**ADC Planning Consultation
Response from the Conservation Officer**

Application Number	BE/61/14/HH
Address	99 North Bersted, Bognor Regis
Description	Two storey extension.
Case Officer	Janice Chapman

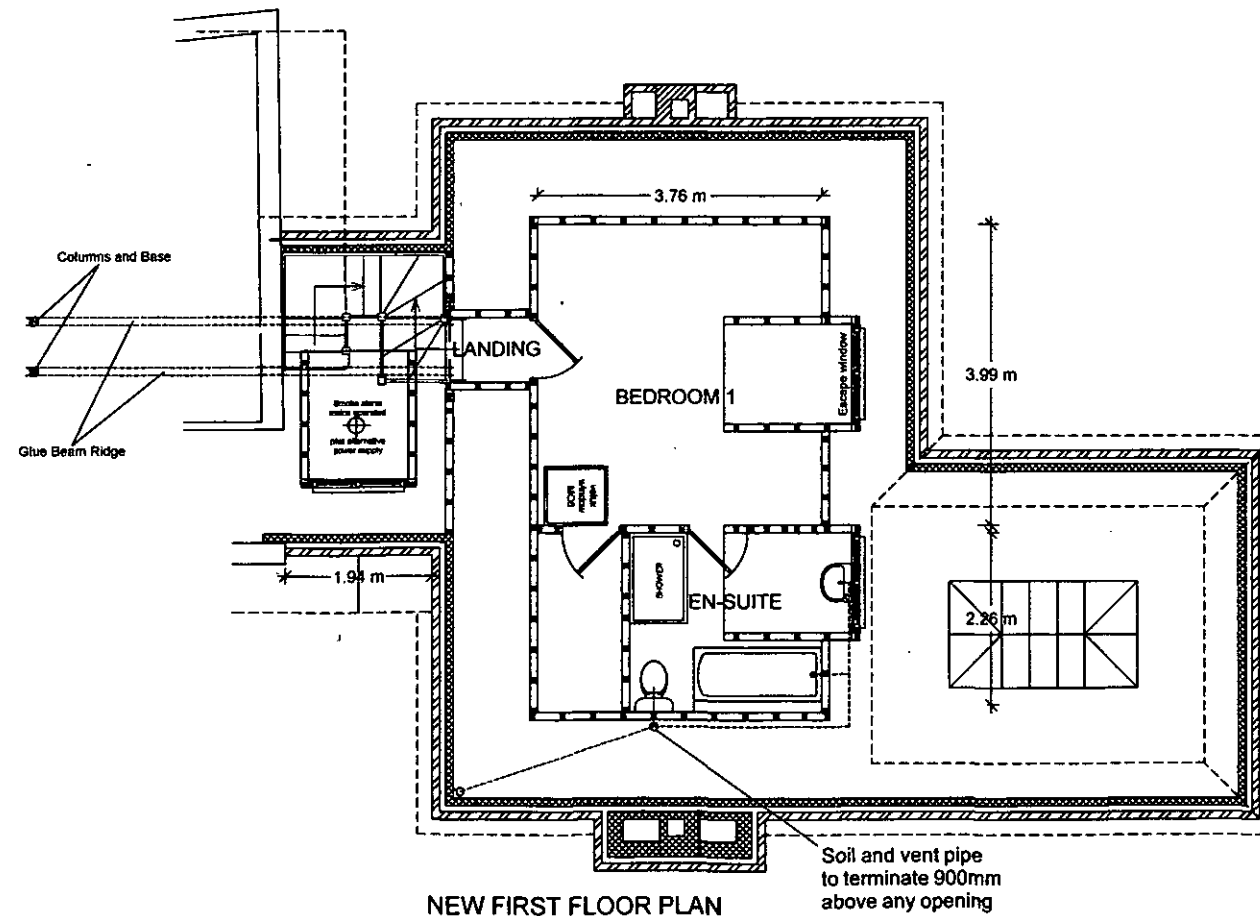
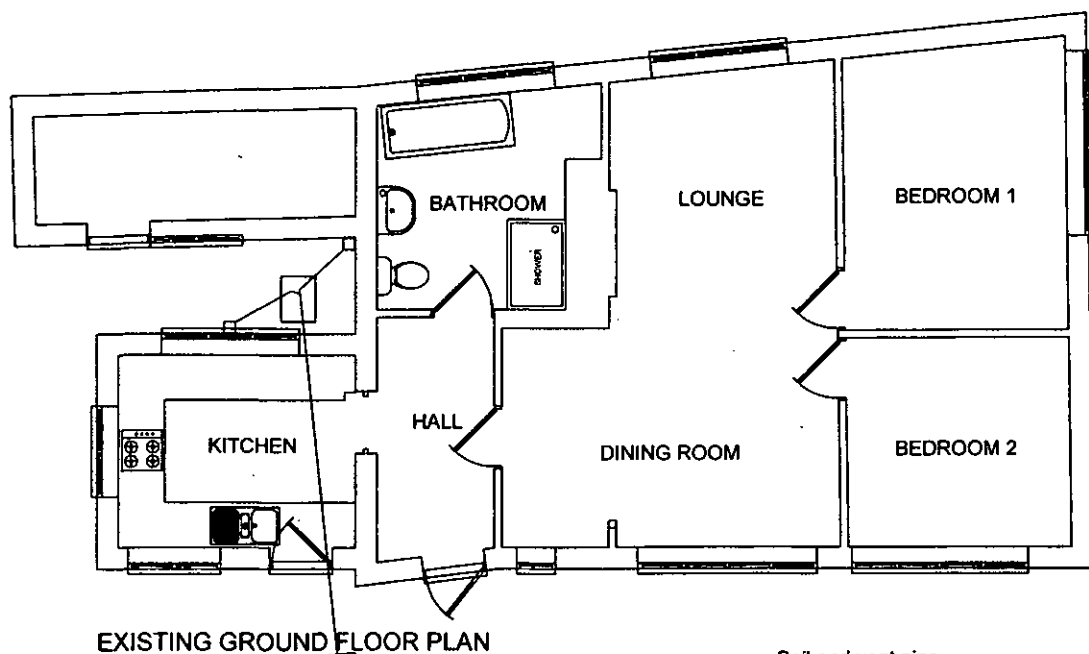
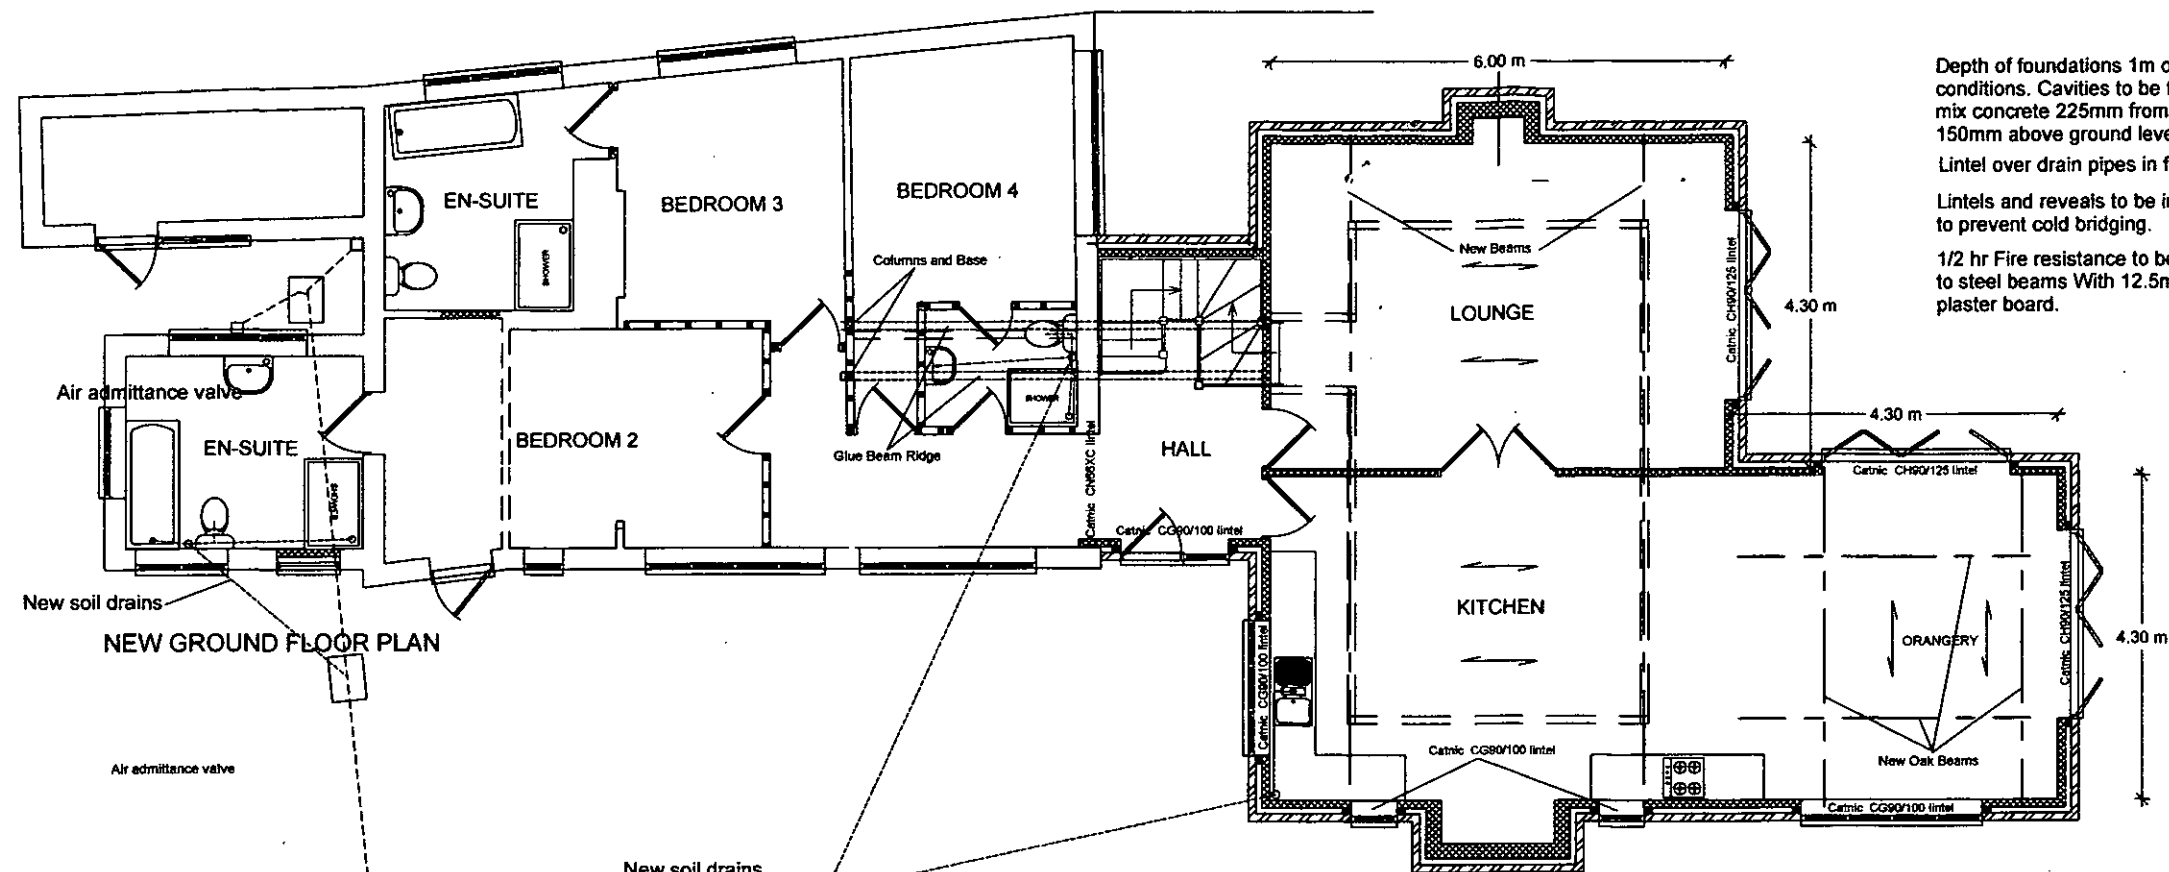
The extension would also result in a new opening to link the existing property to the extension, and the loss of historic fabric.

NEW NORTH EAST ELEVATION

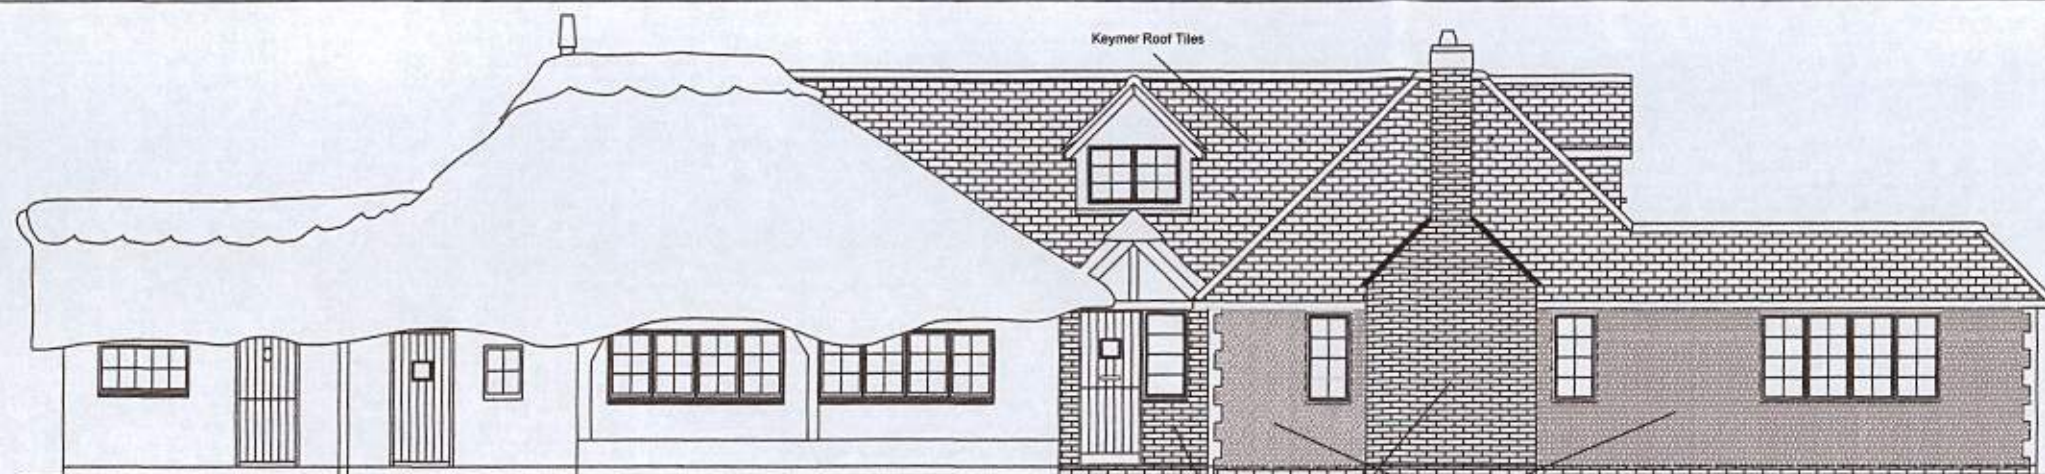
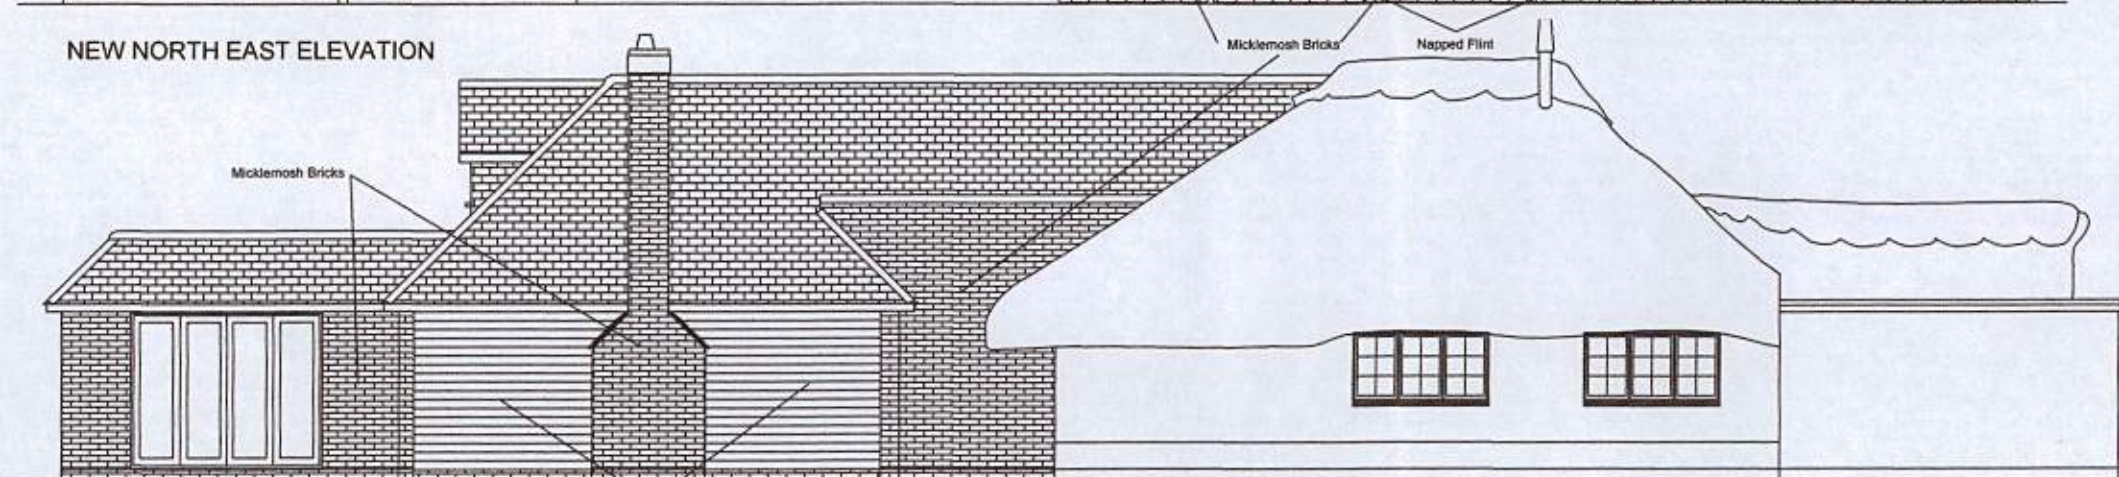
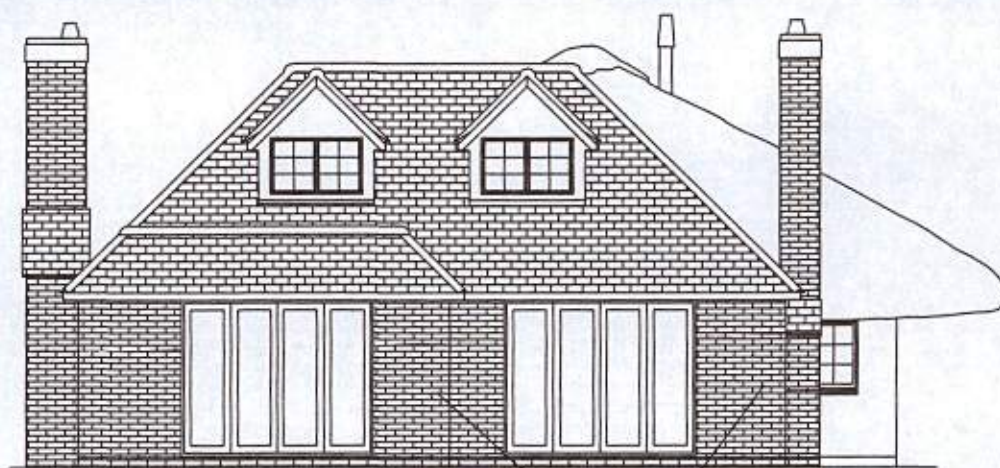
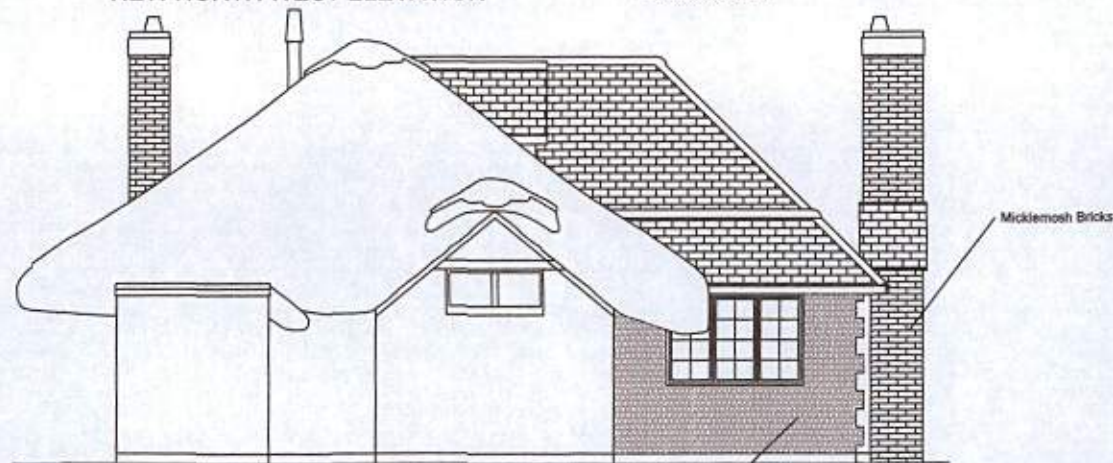
However, given the potential historical importance, scale, character and age of the property, the proposal is considered extremely problematic. The proposed extension is a substantial structure (it reads as if doubling the size of the cottage) which is considered to both overwhelm the existing property and damage its original character. It therefore is not subservient to the existing property.

Every building has a finite capacity for extension; that is to say that some buildings cannot accommodate an extension due to their particular architectural design, simple vernacular form or their location. It is considered that this property, due to its contained, small scale nature, with a substantial, attractive thatched roof, is one such example.

Further, the complexity of the extension is also problematic, for example as witnessed in the means by which the front entrance door and porch are treated.
